Block 20a EDMONDSON PARK AFFORDABLE HOUSING

RESPONSE TO KEY ISSUES

Project Address Lot 401, Lot 402, Cnr MacDonald Rd +
 Buchan Ave, Edmondson Park, NSW 2174
Project Number 2518
Phase State Significant Development Application
Version -
Date Issued 27.07.2026
Prepared by CH
Checked by AA

This Response to Key Issues has been prepared by Fuse Architects in response to the Key Issues Letter received from DPHI (dated 1 July 2026). This is in support of an application for a State Significant Development (SSD-99909708) for infill Affordable Housing at part Lot 40 DP1286151 (future lots 401 and 402), Edmondson Park, also known as Block 20a. Block 20a is subject to development approval (DA-421/2025) which will subdivide Lot 40 into several smaller allotments. The development will be constructed on Lot 401 and relies on Lot 402 which is dedicated to becoming a future laneway.

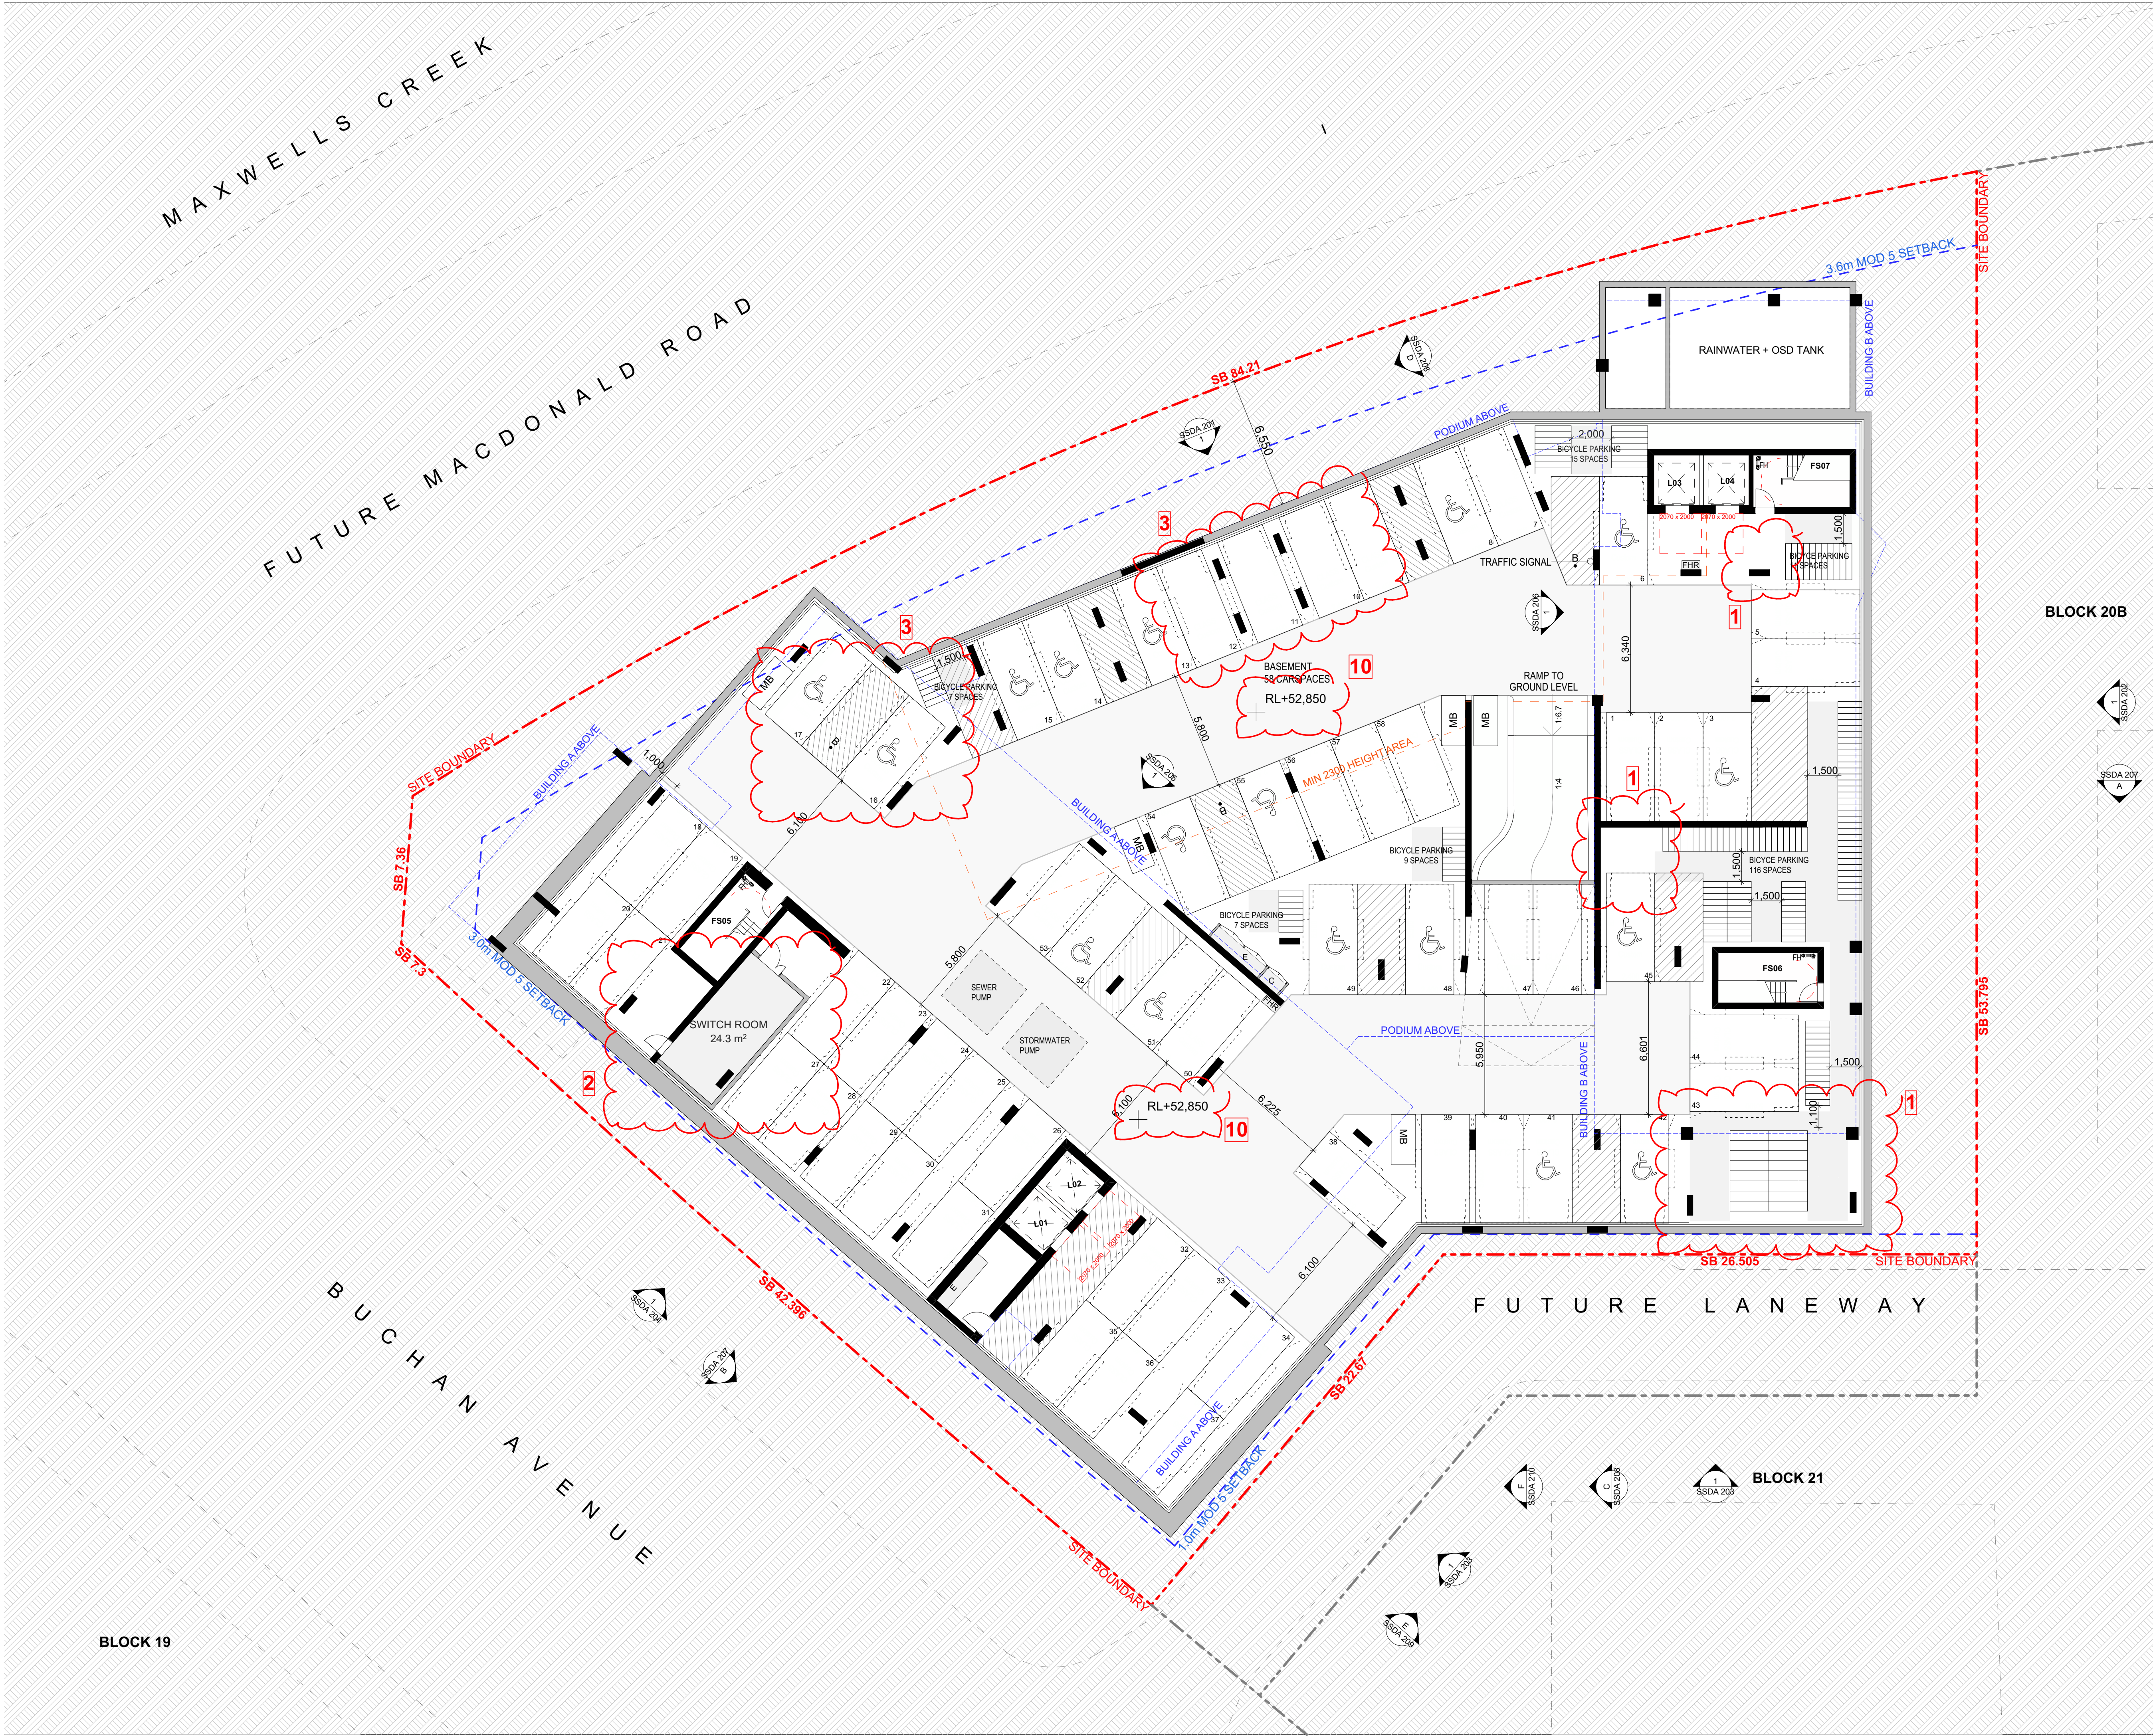
Basement 01 Plan shows car parking spaces including 38, 54, and 58 overlapping with adjoining spaces or walls. The Department requests that you confirm all car parking spaces comply with the required minimum dimensions and do not intersect with other components in the basement.

Inconsistencies have been identified between the Design Report and Basement 01 Plan regarding the location of the switch room, bicycle parking and storage. The Department requests clarification and consistency across all documentation on the location of these components.

Updated plans are provided confirming all car parking spaces comply with the required minimum dimensions and do not intersect with other components in the basement.

Inconsistencies have been checked and corrected across all documentation.

5 PRIVACY SEPARATION - LEVEL 09-14

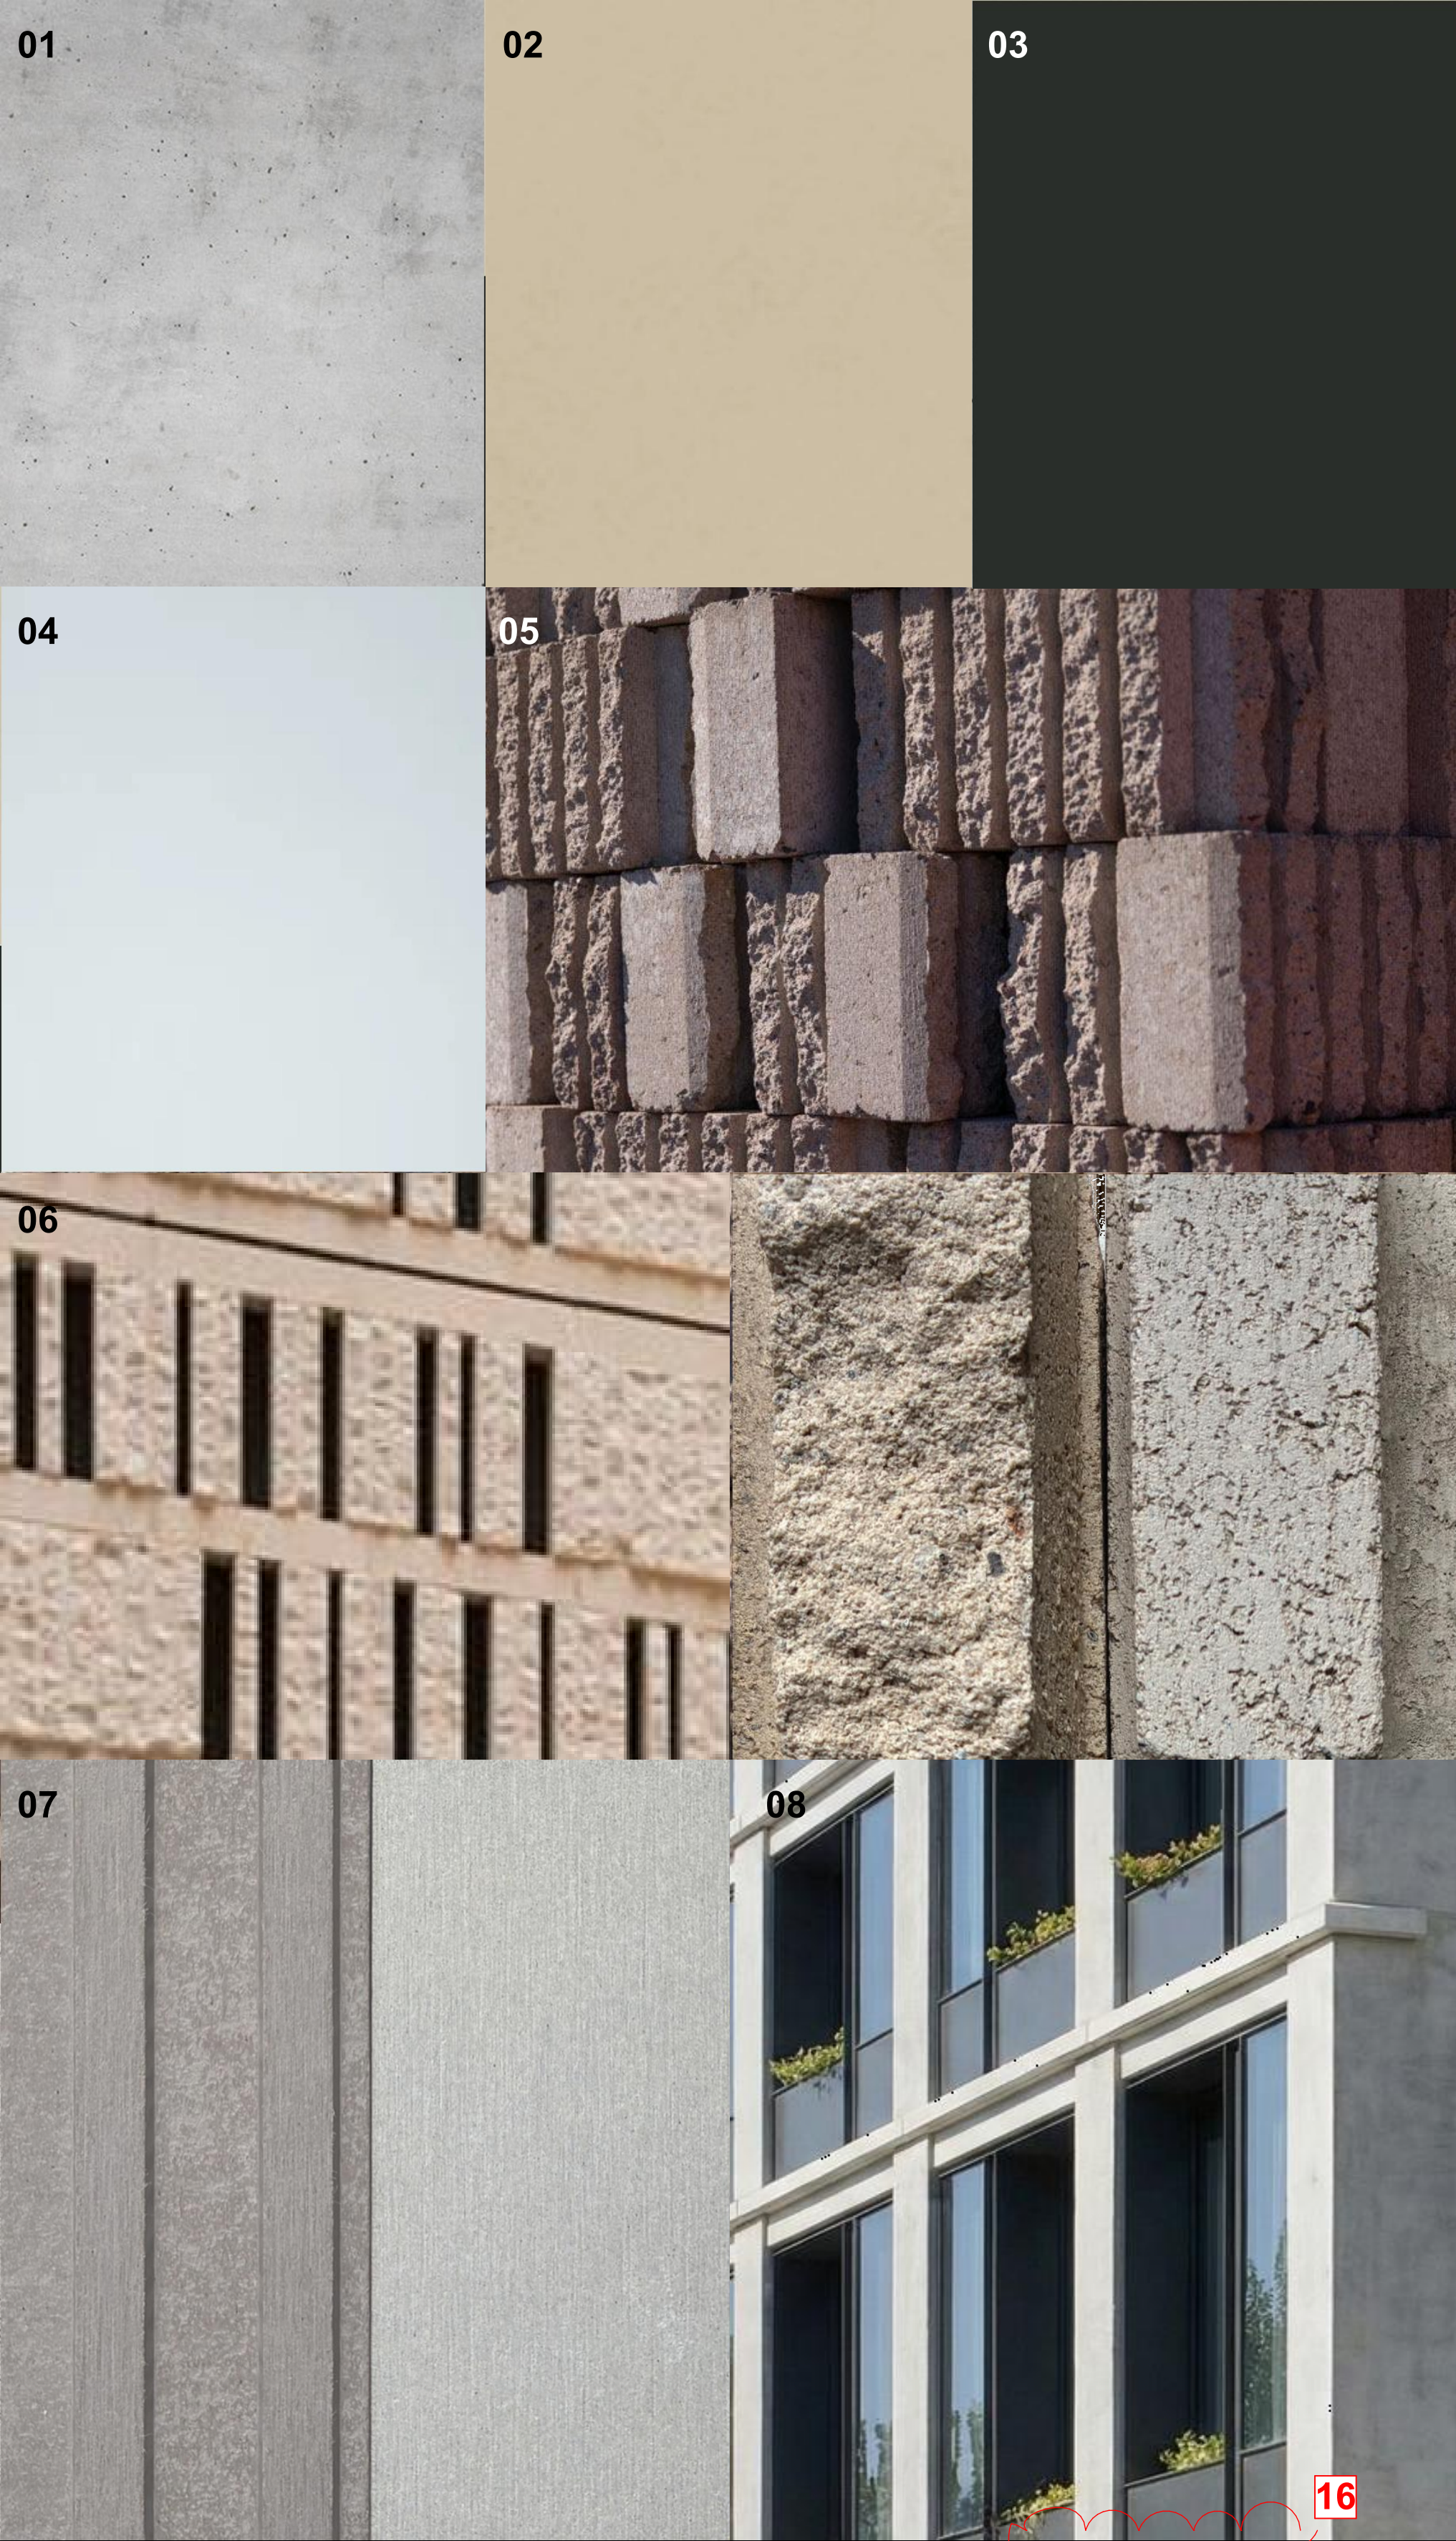
The Department requests that the interface conditions of windows adjoining habitable rooms and balconies between Building A and Building B be reconsidered to increase privacy and amenity or justified having regard to the ADG objectives (see Figure 1 below).

Objective 3F-1 of the Apartment Design Guide (ADG) states that building separation is to achieve reasonable levels of visual privacy and provides minimum separation distances for habitable room windows and balconies.

The proposed separation between levels 2 to 8 at Building A and Building B is 9.3m at the closest point which does not meet the design criteria of part 3F-1. As the buildings are on the same site, a minimum separation of 12m (up to 4 storeys) and 18m (5-8 storeys) is recommended.

The proposed design has provided for offset windows so that the 2 units do not directly overlook each other.

An additional privacy screen is proposed to provide further privacy between the 2 units.
